WEST SUSSEX COUNTY COUNCIL CONSULTATION

TO:	Arun District Council FAO: Anita Gardner
FROM:	Stephen Gee, Highways, WSCC
DATE:	14/02/19
LOCATION:	Land south of the A259, Grevatt's Lane, Climping, BN17 5RE
SUBJECT:	CM/4/19/PL Construction of a crematorium comprising of a crematorium building & associated structures, car parking, access & landscaped spaces. This application is a Departure from the Development Plan.
DATE OF SITE VISIT:	11/02/2019
RECOMMENDATION:	☐ Advice ☒ Objection ☐ Modification ☐ No Objection ☒ More Information ☐ Refusal
S106 CONTRIBUTION TOTAL:	£ See below for breakdown.

Drawn BW	Checked DM	Approved (DF)
Original dwg. size A3	Date of Issue Dec 2018	Scale 1:1000
Drawing Status PRELIMINARY	Drawing Number BWREDE-SK01	Rev. P2

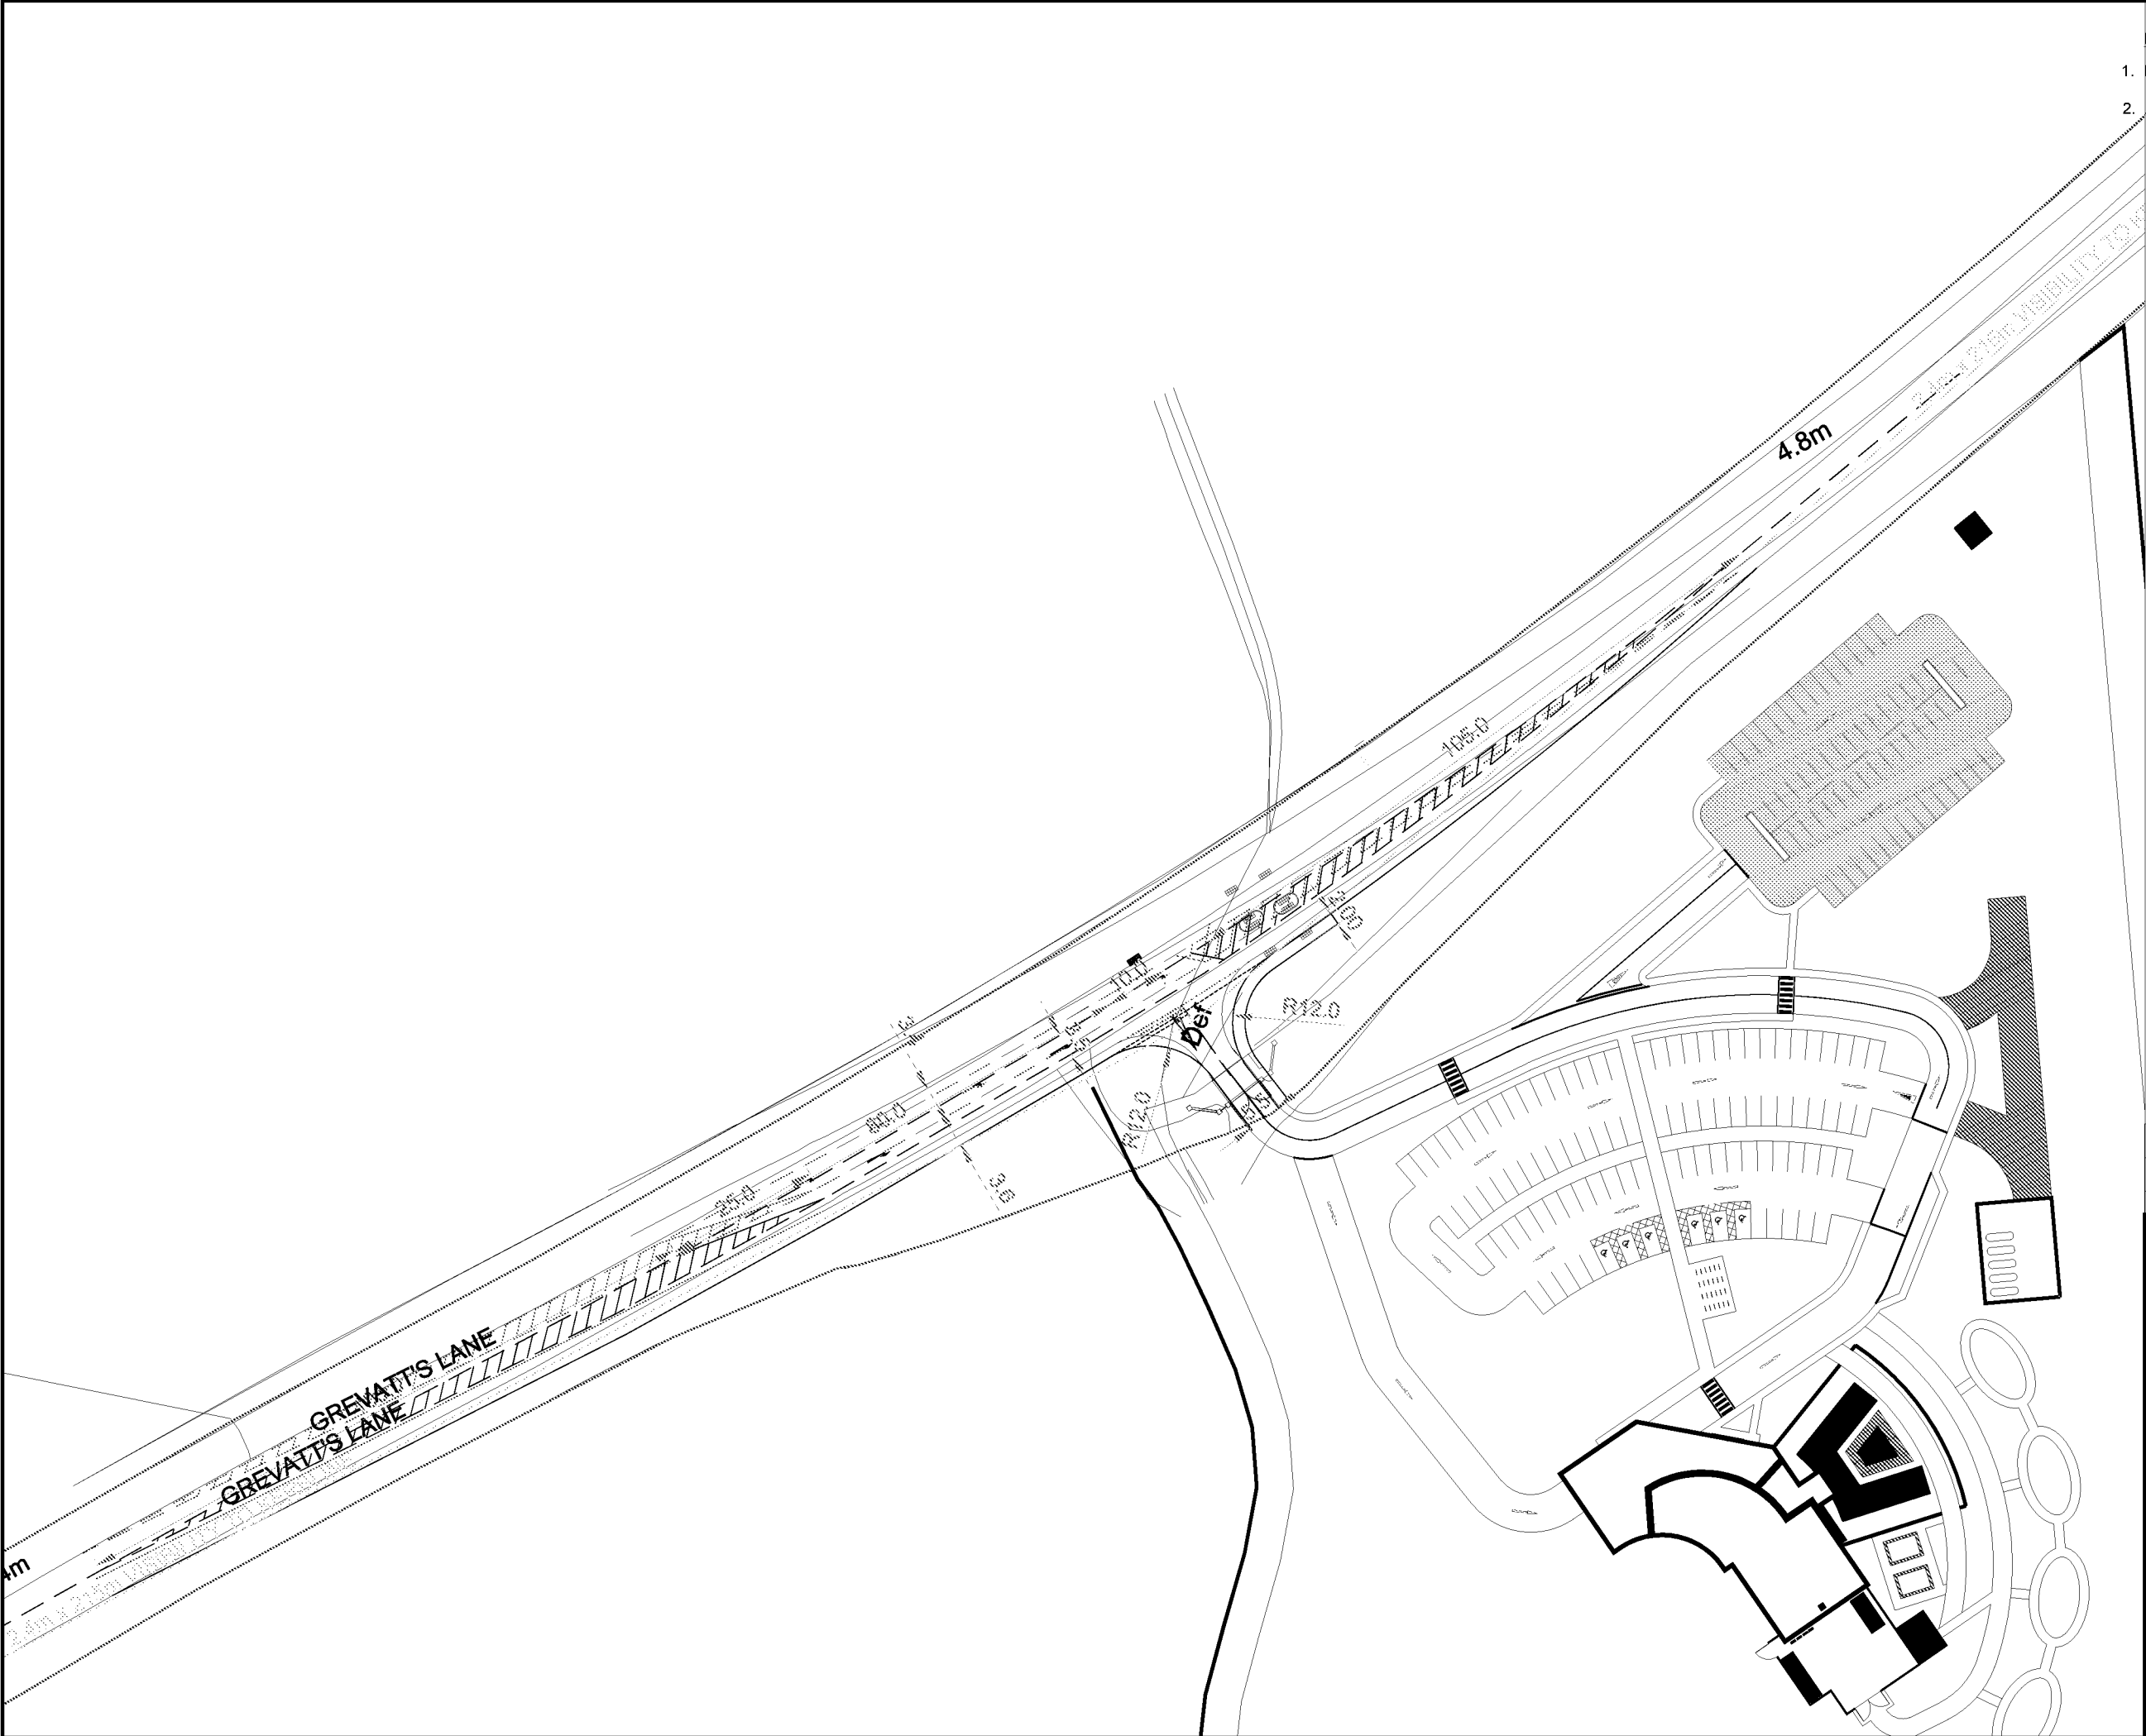
Drawing ref BWREDE-SK01 has been provided to show the proposed access however it appears to have two iterations of the design included – e.g. showing two pedestrian islands to the east. It is also noted that no safety audit has been provided in line with the WSCC Safety Audit policy and as such an objection is raised to the proposals.

To the north of the A259 is the NCN 2 shared use cycleway which provides a link between Littlehampton and Bognor Regis. The 700 bus service runs along the A259 with the nearest stops in close proximity to the Oystercatcher junction approximately 1.1km to the east. The service runs approximately every twenty minutes between Littlehampton and Chichester (via Bognor). The site access proposals provide a pedestrian refuge to support crossing movements across the A259. The width of the island provided should be identified on the general arrangement plan.

- Safety Audit and if appropriate designers response.
- Revised site access drawing.
- Junction modelling of the site access.
- Confirmation regarding the extent of the service area
